Subject: Kirkburn Parish Council - Concerns in relation to the CCS depot at Kelleythorpe

Inset of proposed Construction Compound and Storage Area at - Alamein Barracks Driffield. YO25 9HD  
Scale 1:2500 @ A0

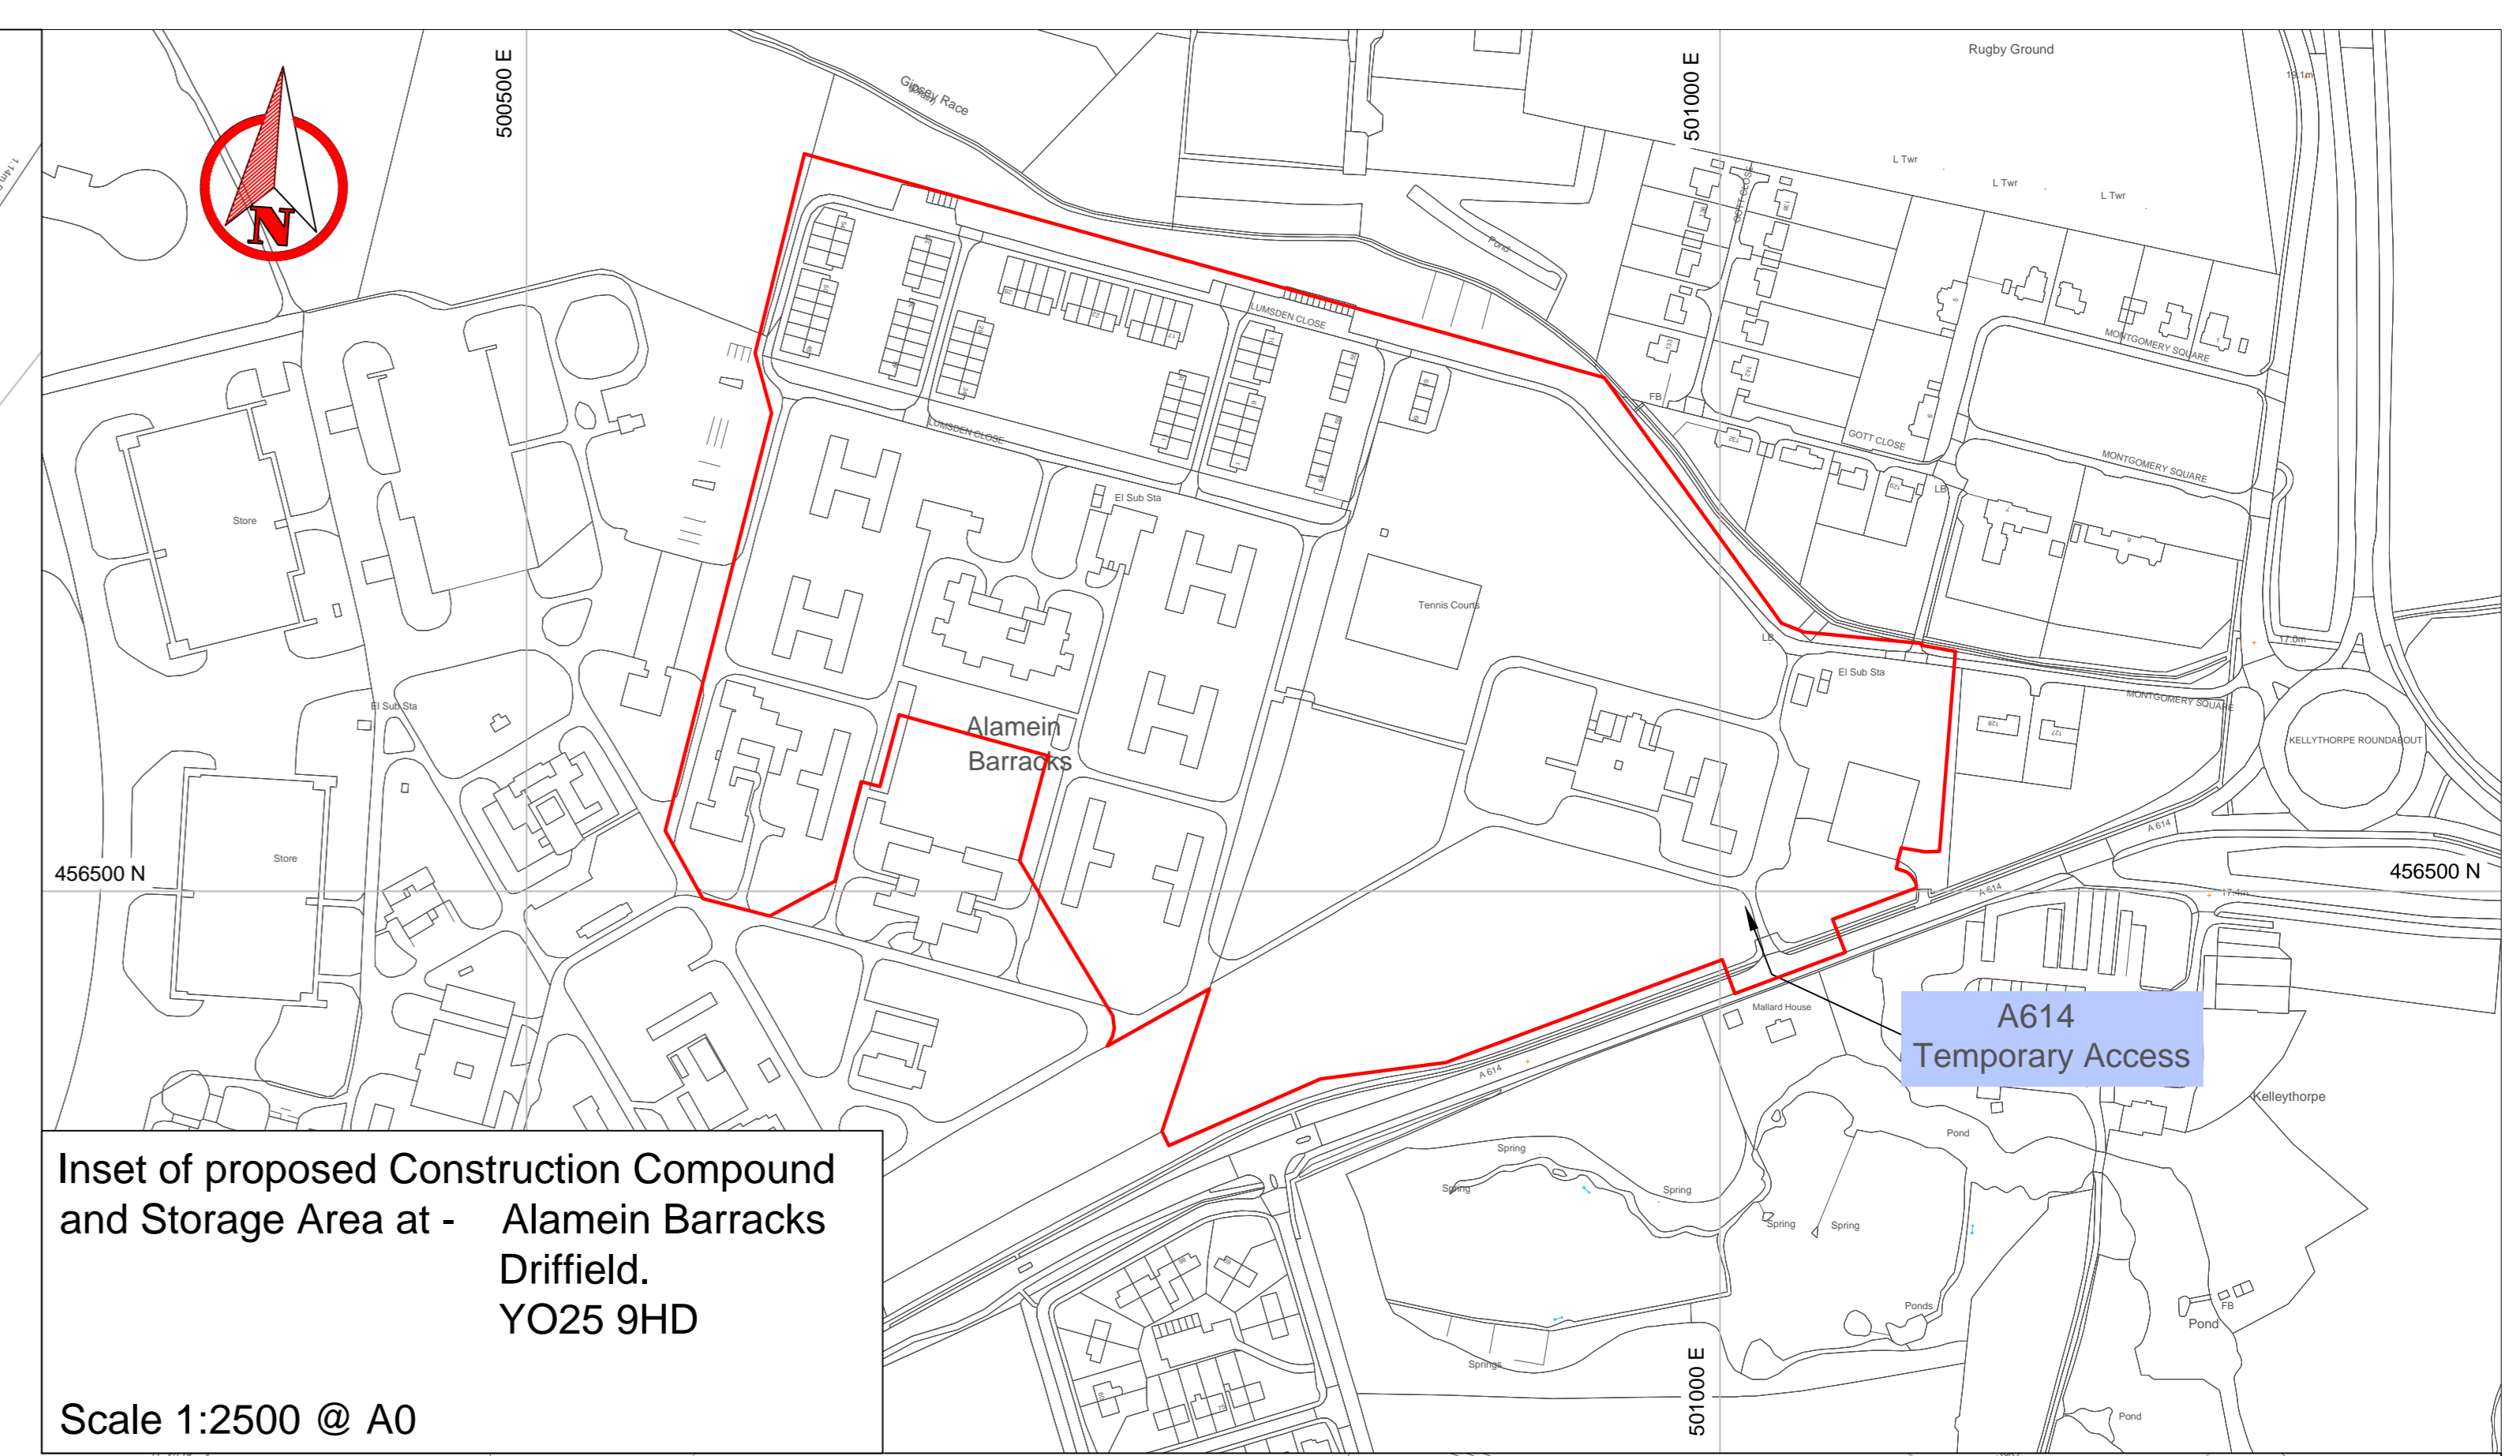
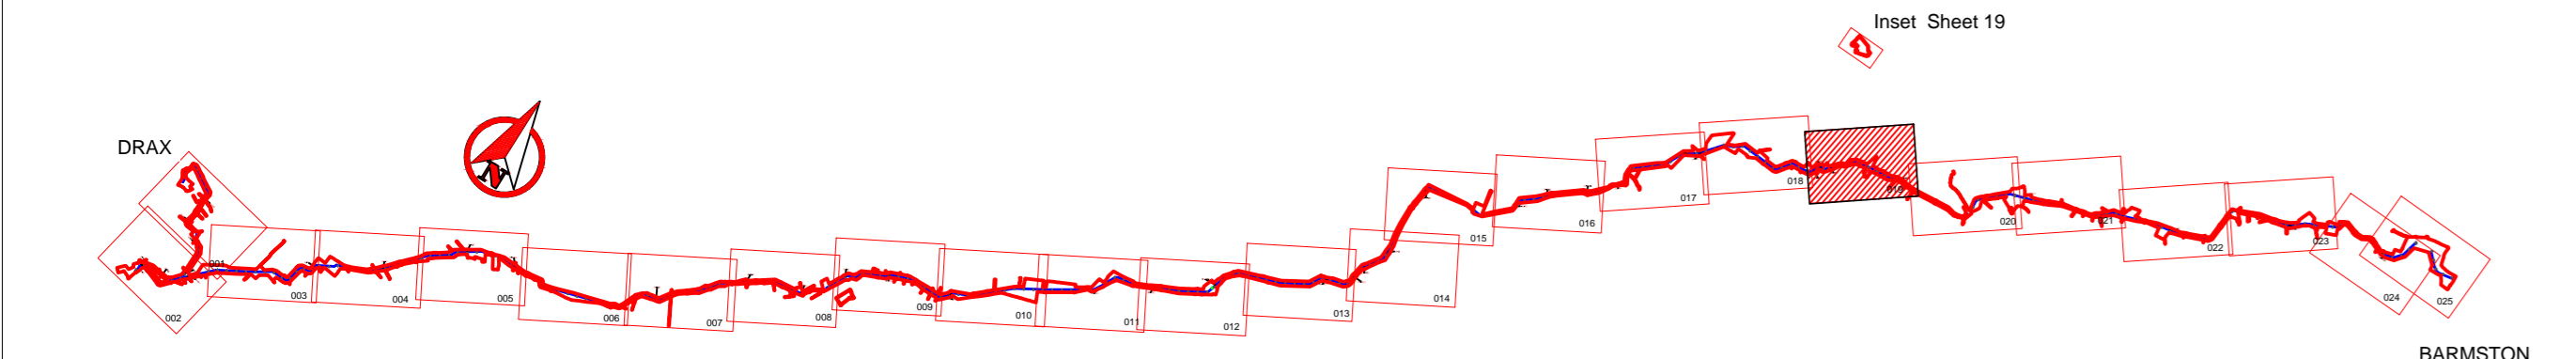
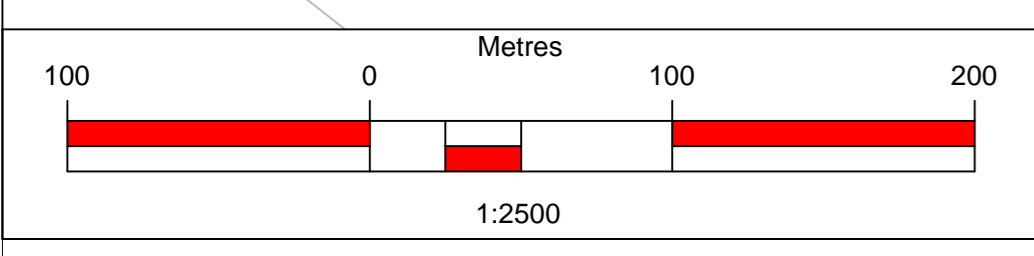
1. The access will be directly opposite, and within 25 metres of, Mr & Mrs Webb-Ingall's home, Mallard House This will subject them to noise, dust and fumes during the preparation of the Construction Compound, as many tonnes of construction spoil on the site will need to be removed, and its subsequent use.

2. The access is currently too narrow to accept construction traffic. Widening of the access will result in the removal of four mature, healthy trees. This is unacceptable from an environmental aspect and also from the position that it will remove any screening of the Construction Compound, and subsequent housing development that is proposed for the site in the near future under East Riding of Yorkshire Council's (ERYC's) Local Plan, for Mr & Mrs Webb-Ingall.

3. The proposed site entrance will exit onto the A614, the major trunk road from the M62 to Driffield and Bridlington, it also carries traffic from the M62 to the other major Yorkshire coastal towns of Hornsea, Filey and Scarborough. The section of road where the proposed entrance will be feeds into the Kelleythorpe Industrial Estate and is already a bottle neck during the summer months (which is the time of year when the work associated with the CCS project will be at its height) with traffic backing up from the roundabout along the A614 in both directions. Indeed residents of the estate which exits onto the A614 via nearby Auchinleck Close have previously expressed concerns to officers of ERYC regarding the difficulty of egressing onto the A614. This would be compounded if permission were granted for the use of the proposed entrance.

4. Although there is the potential for bringing more trade to the nearby Sunderlandwick Farm Shop there is the distinct, and more likely, possibility that trade may be affected if customers experience, or perceive there may be, problems accessing or egressing from the Farm Shop. Have the National Grid carried out an Impact Assessment on the potential impact for trade for this establishment?

5. If National Grid wish to locate their Construction Compound within this local area there are much more suitable options available. Within 500 metres, to the west of the proposed entrance, is an established entrance for HGVs and MOD vehicles accessing the grain/goods storage hangers and the MOD

vehicle training area. There is large existing external hardstanding which could presumably be utilised for storage of portacabins, equipment and pipework following negotiation with the landowner. Alternatively there are other potential areas to lease land in the vicinity; Kelleythorpe Industrial Estate, Skerne Road Industrial Estate (Drifffield) and Hutton Cranswick Industrial Estate. All have established entrances for large vehicles and are within the correct geographical area to support the CCS project.
